**WEST SUSSEX COUNTY COUNCIL
INFRASTRUCTURE CONSULTATION**

SUBJECT: P/117/09 - Outline application for proposed demolition of existing sub-standard bungalow for erection of two bedroom bungalow with associated driveways.

Springfield, Nyetimber Lane, Pagham, Bognor Regis, PO21 3JX

outline planning permission with all matters reserved for demolition of sub standard bungalow for erection of two-2 bedroom bungalows with associated access driveways. Springfield, nyewood lane, pagham, west sussex.

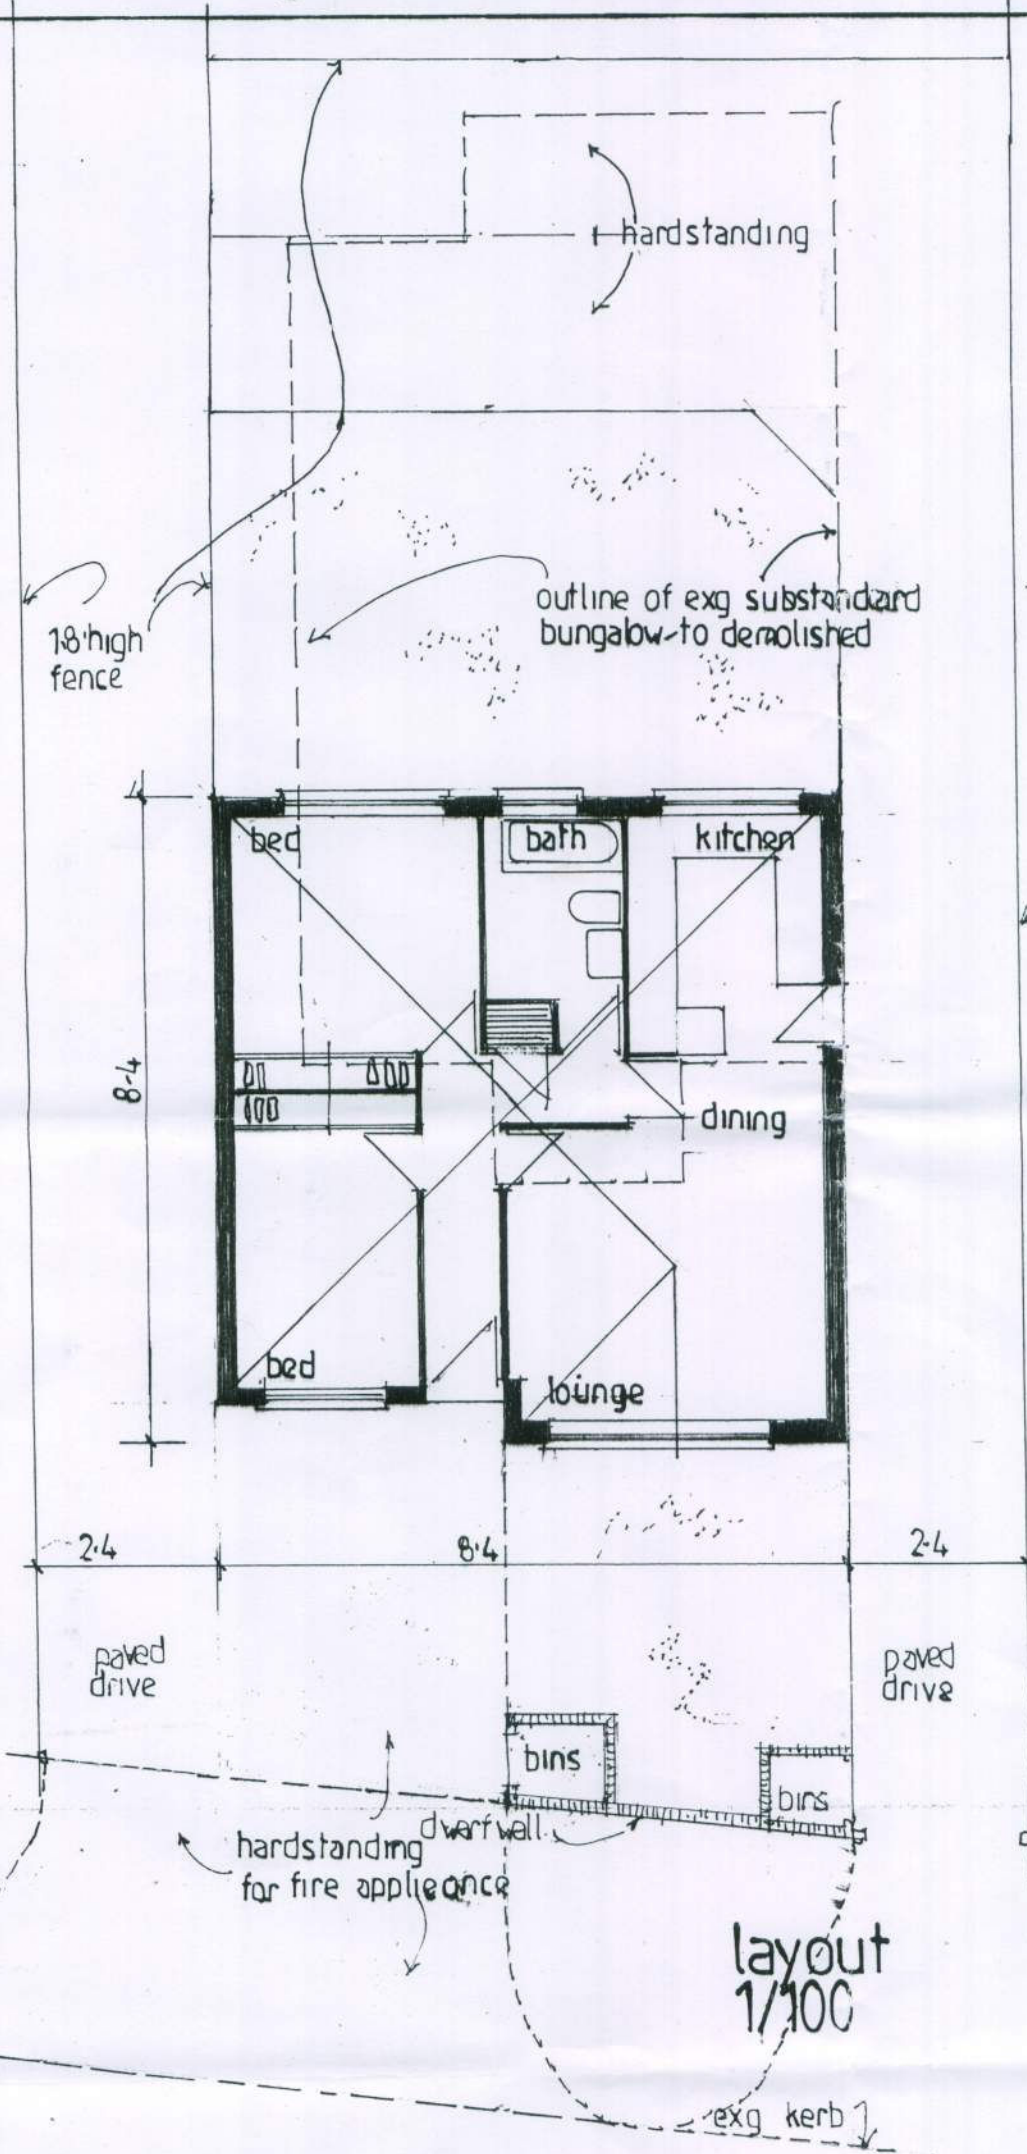
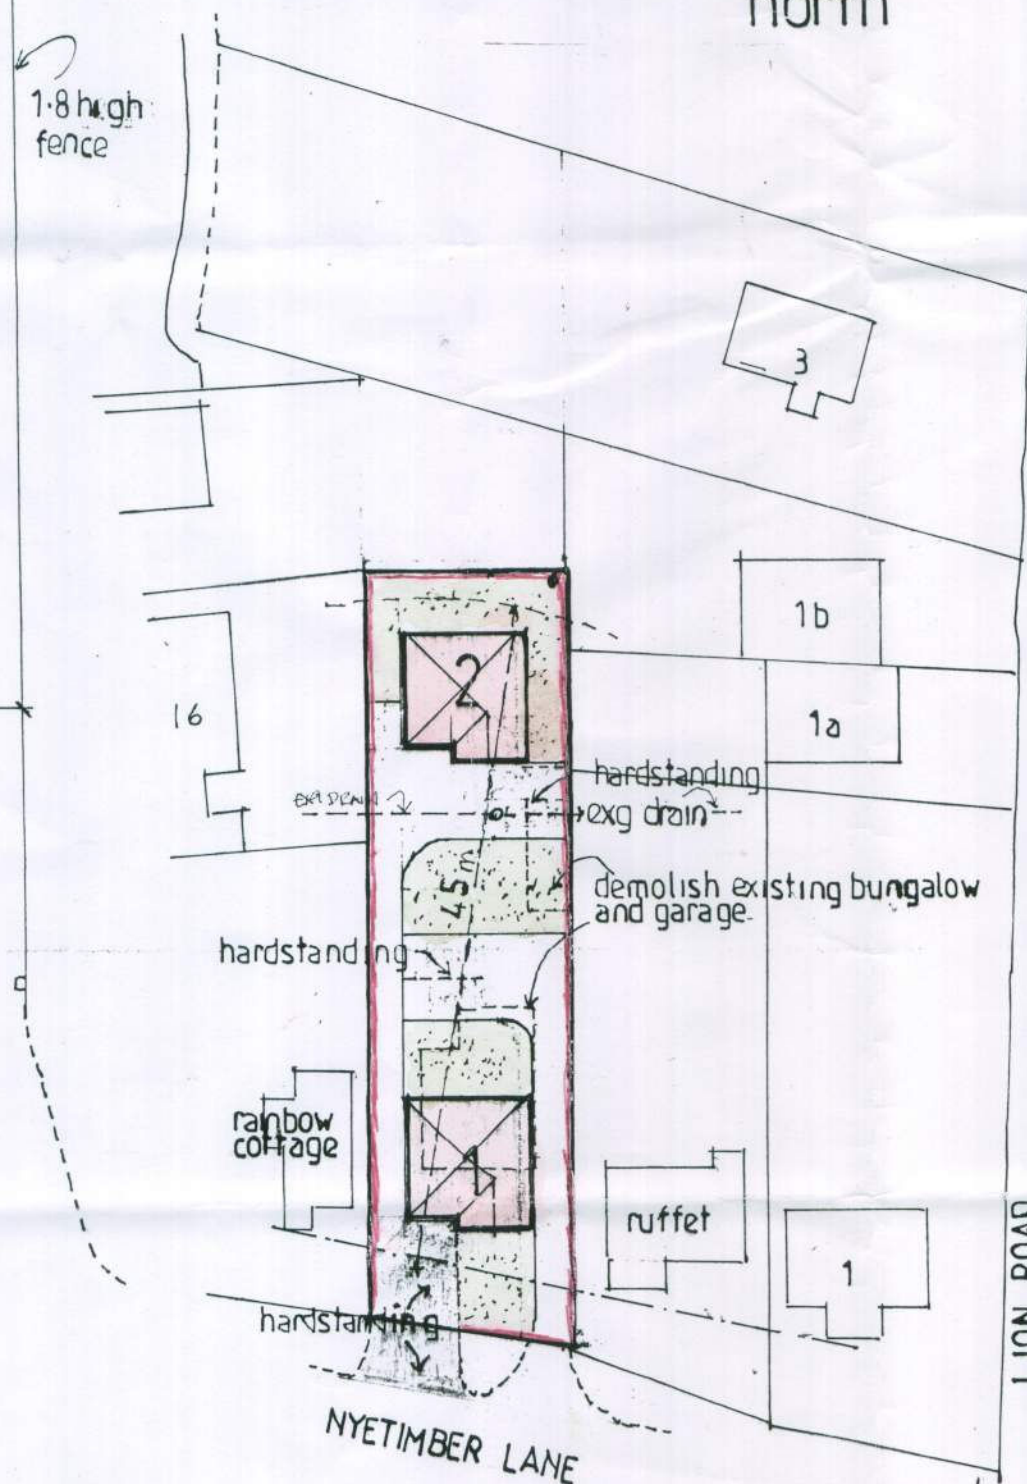
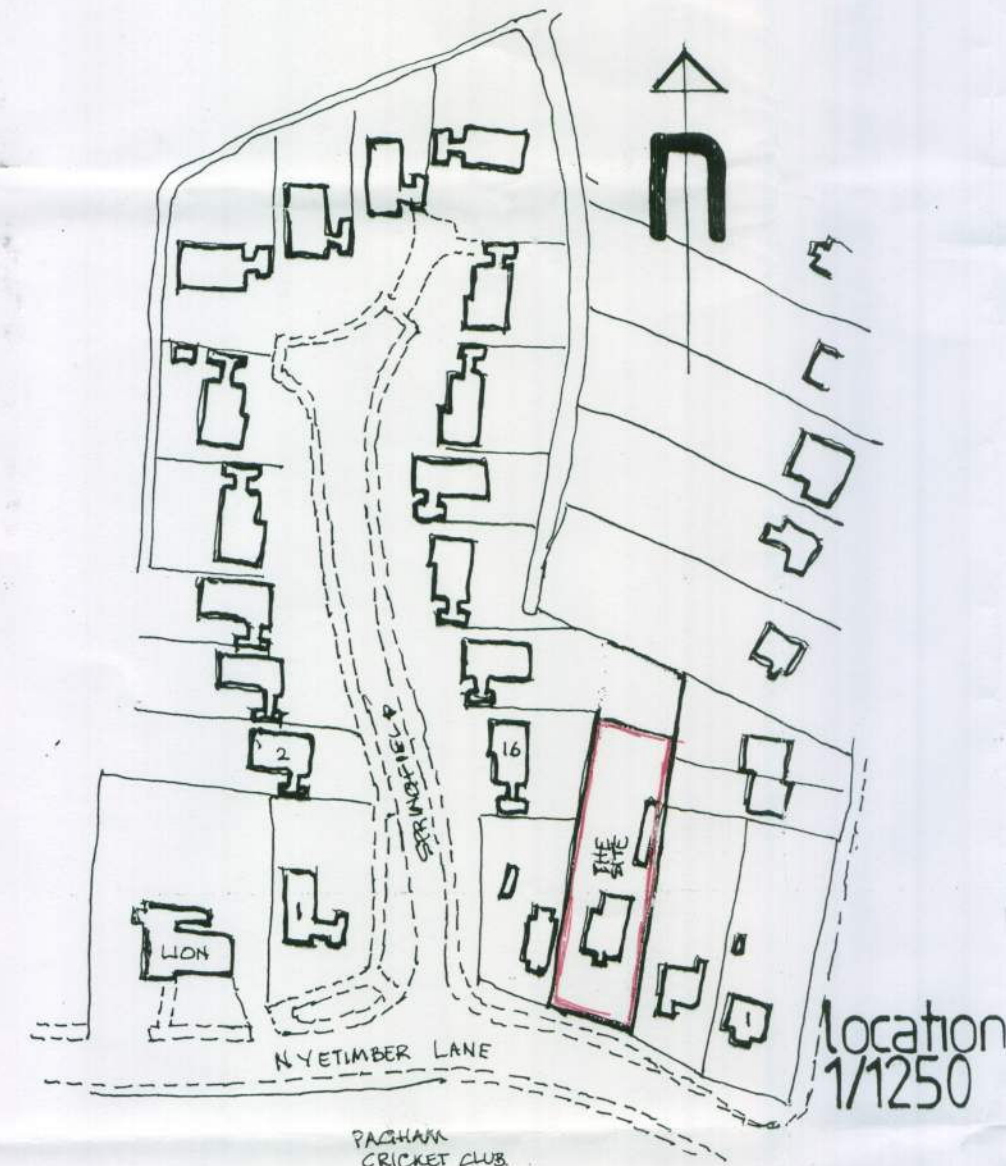
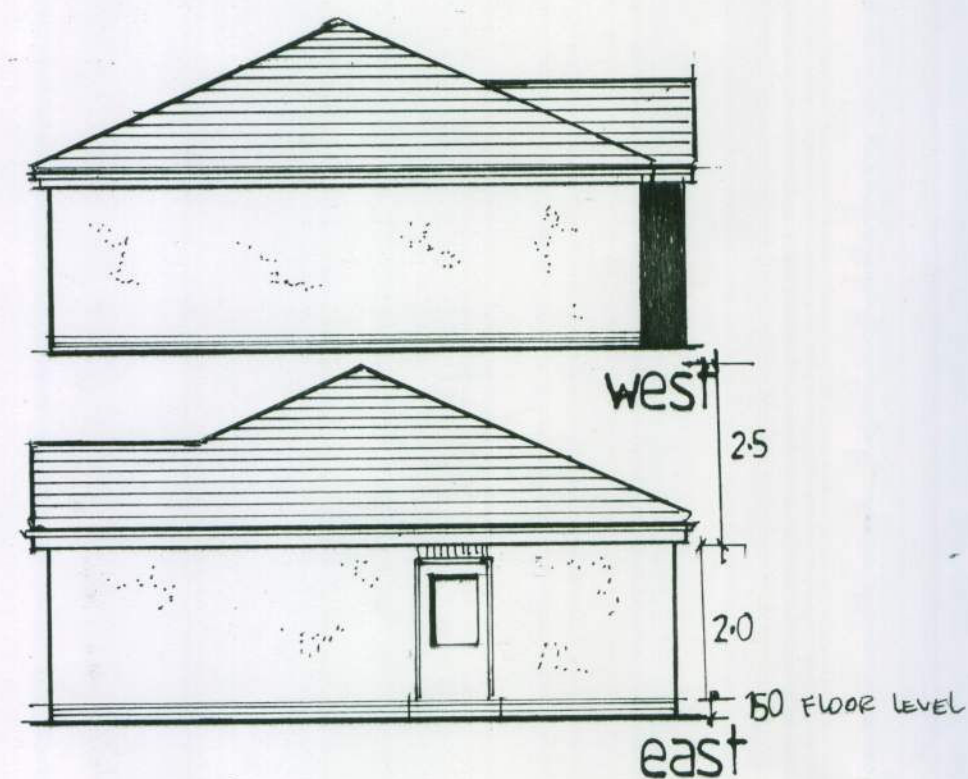
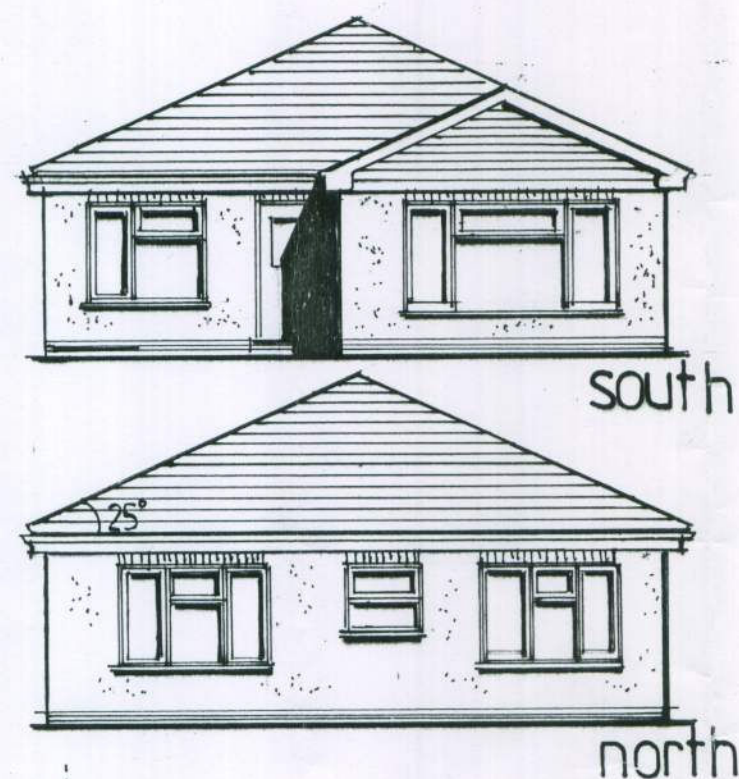
The existing access will serve bungalow number one and a new access is proposed to serve bungalow number two. Given that the proposed new access is only serving the one dwelling a 3 metre wide access is considered sufficient. Any works on the highway must be agreed with the WSCC Local Engineer and carried out under licence. I would also require the driveway area and car parking spaces to be constructed in a bound material and that suitable drainage methods are installed to prevent private surface running onto the public highway. The proposed crossover to access the new driveway will require visibility splays of 2m for pedestrians, not shown on the proposed plans; this will require any proposed planting to be no higher than 0.6m above the ground level and any existing foliage to be maintained in order to safeguard the visibility splay.

It would be beneficial for details of the car parking to be confirmed to demonstrate that satisfactory car parking arrangements can be provided. On the basis that four spaces are proposed, the parking provision is within the WSCC Parking Standards, and no highway safety concerns would arise through this provision. The Planning Authority may wish to consider the implications of this proposal upon on-street car parking.

Cycle parking should be included however; this must be secure, covered and be capable of storing at least one cycle per bedroom of the proposed bungalows. The actual details of the cycle parking facilities should be submitted to and approved by the Local Planning Authority (LPA). To accommodate cycle parking it would be recommended that any cycle store should have minimum dimensions of 2m x 1m.

If the LPA are minded to approve this application, a condition securing cycle parking, provision of the new access prior to occupation of the dwellings, and pedestrian visibility splays of 2 by 2 metres should be included.
